Your Ref: OWPC16584
Our Ref: BR/194/17/PL 30-06-2017
Please ask for:
Richard Temple

Demolition of the existing Foreshore office & decommissioning of existing underground toilets. New purpose built unisex toilet block including urinals, baby changing facilities & accessible WC, plus a separate beach office with public information point & first aid facilities. All located on the existing seafront promenade.

Promenade Opposite Walton Avenue The Esplanade Bognor Regis

Proposed Elevation North
1 : 50

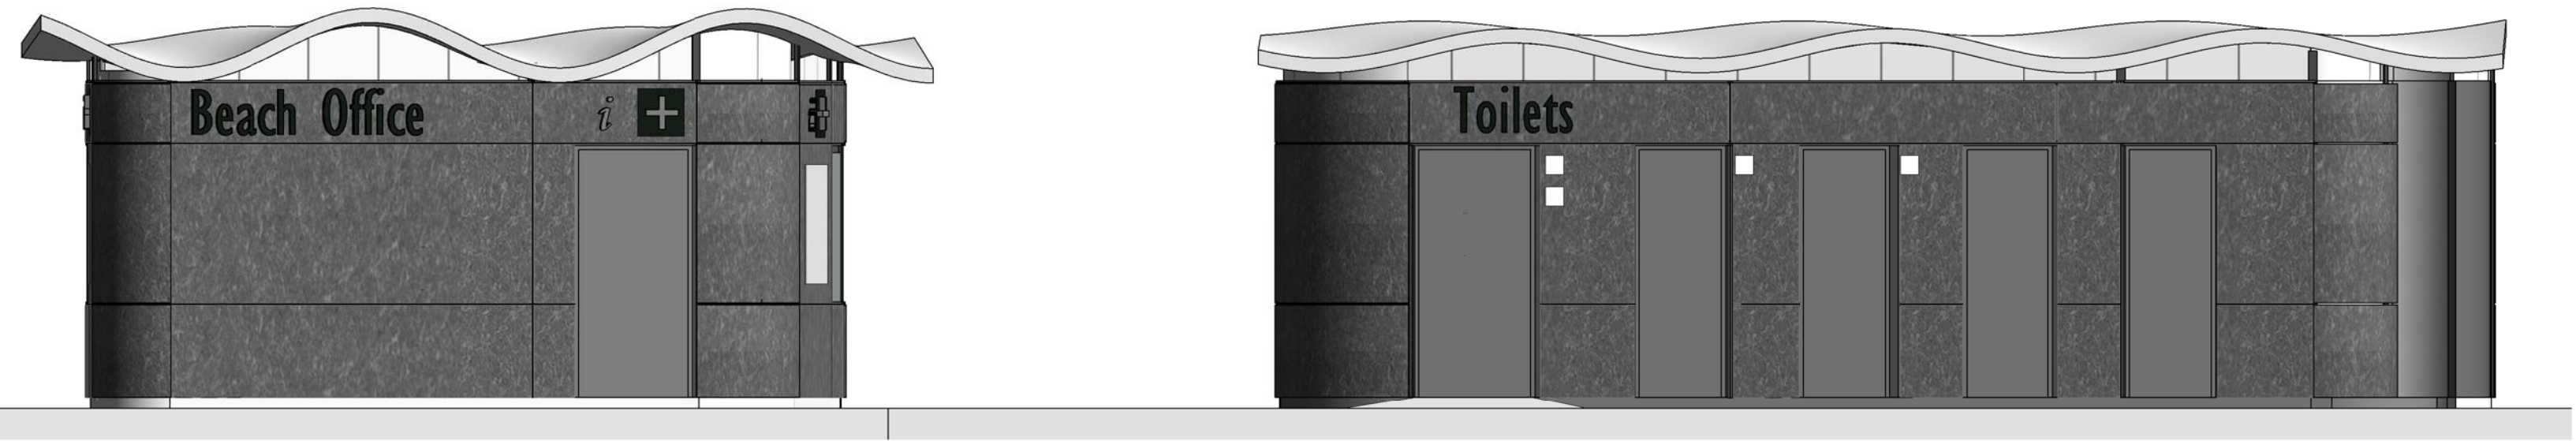
However it is fairly obvious this will never happen, so, can you please remove the signage, on the north face, that will face everybody's windows.

I do not need to be reminded every minute of the day that they are TOILETS

The general public who are likely to use them will be on the prom and will be able to see clearly signage that could be placed on the southern, eastern and western sides.
